**Consultation Response from KC,
Conservation & Design****2022/92977 Northorpe Hall, 53 , Northorpe Lane, Mirfield, WF14 0QL****Erection of wooden cabin, toilet and parking area****Date Responded: 17.10.2022****Responding Officer: Sebastian Pickles****Responding Ref:**

17m² 3m Straight Solar DSR

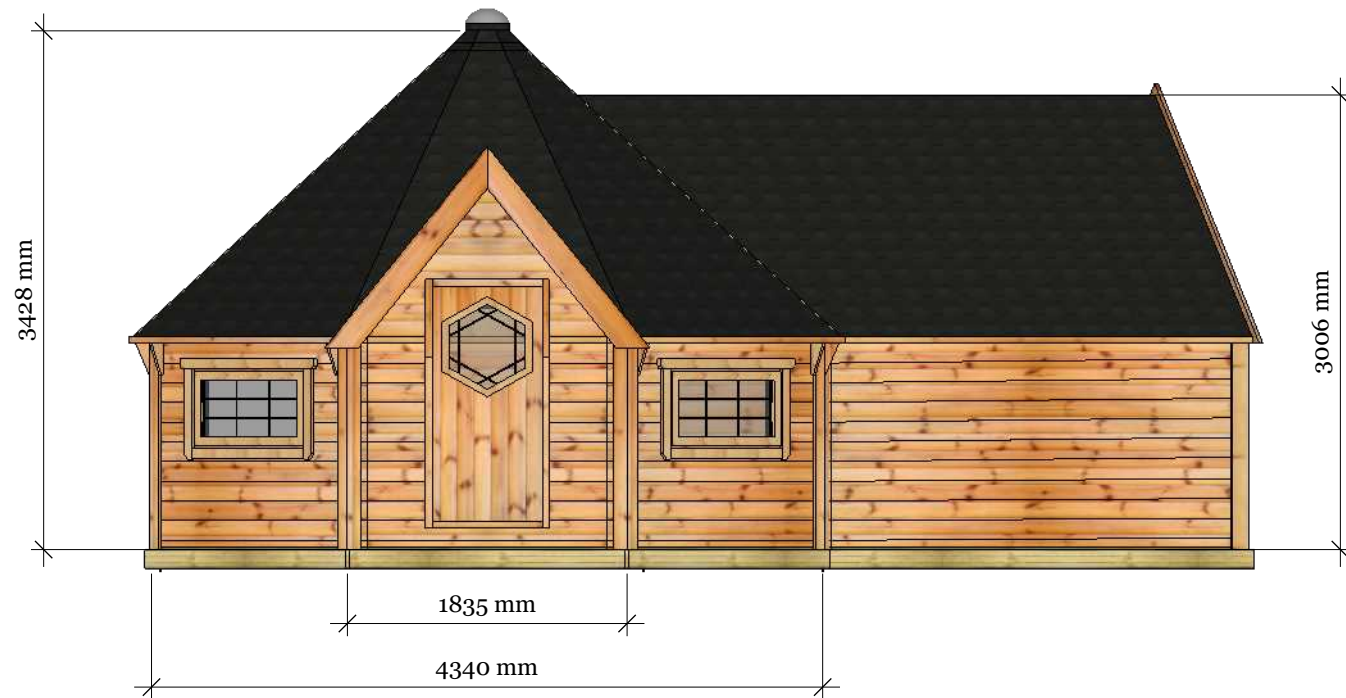
Conservation would raise no objection to proposed timber cabin. The introduction of the cabin will have a minor impact on the setting of the Hall and Barn and still allows for the views onto the site. We would however ask that the proposed roof material is amended from felting shingles to timber shingles. This will provide further visual mitigation, as the proposed felt shingles will provide a harsh visual impact. This could be secured by condition is required.
